**EL PASO COUNTY PLANNING AND
 COMMUNITY DEVELOPMENT
 DEPARTMENT**

GRADING AND EROSION CONTROL PLAN CHECKLIST

Revised: July 2019

WEST SFB DETAILS
1" = 20'

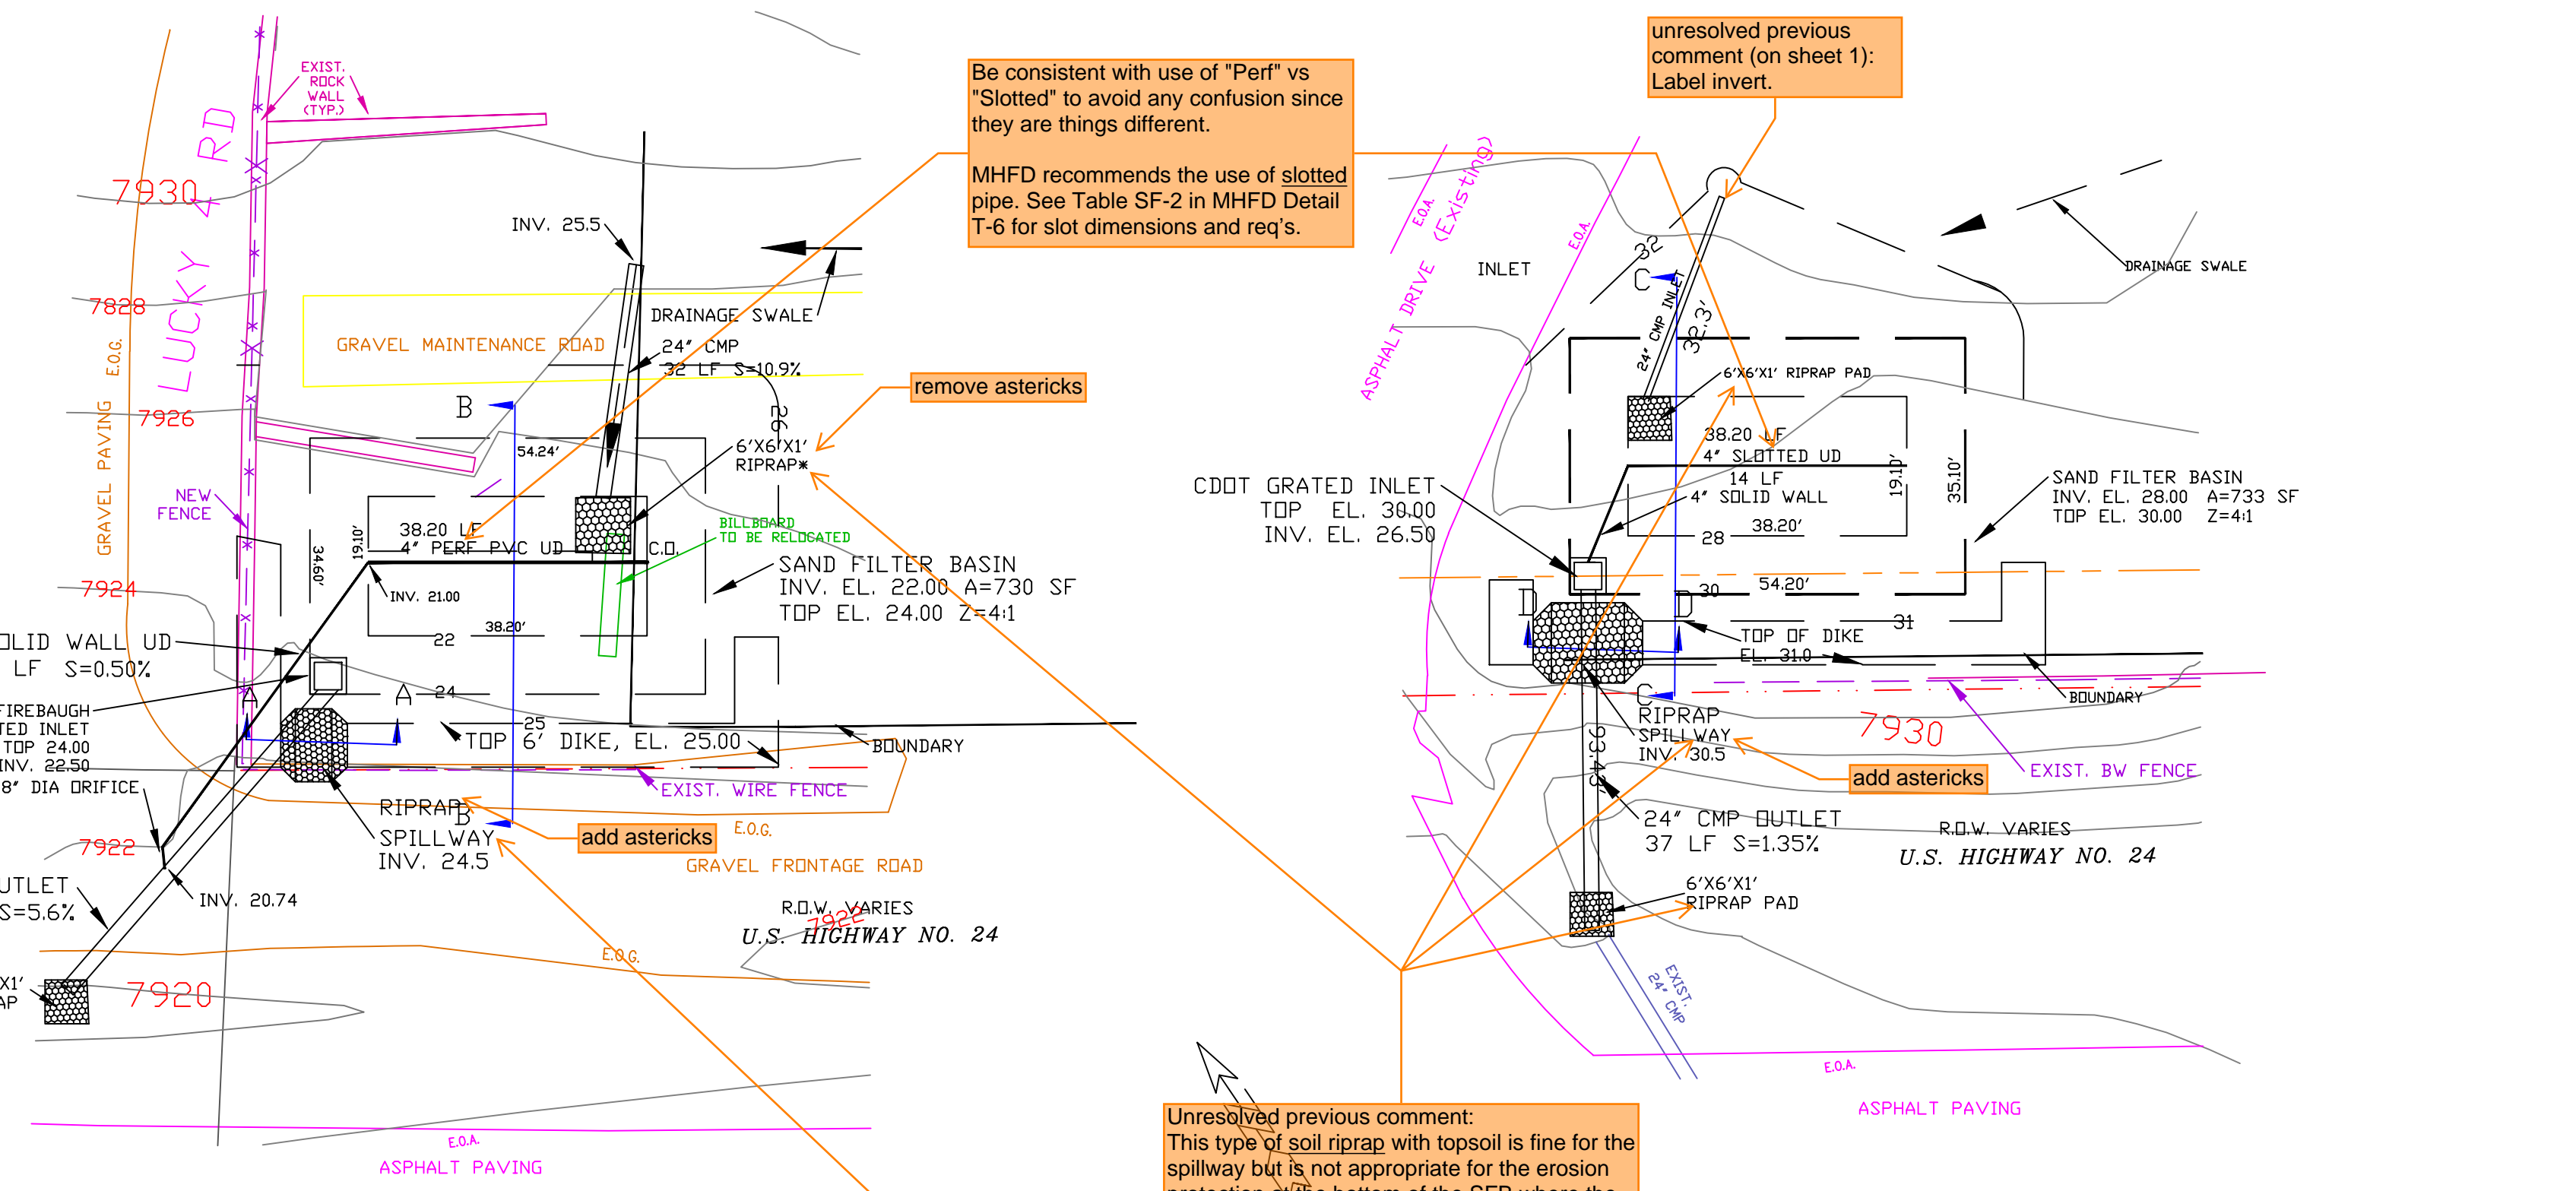
Revise to "x"

Revise to "x" as there are 2 proposed SFBs
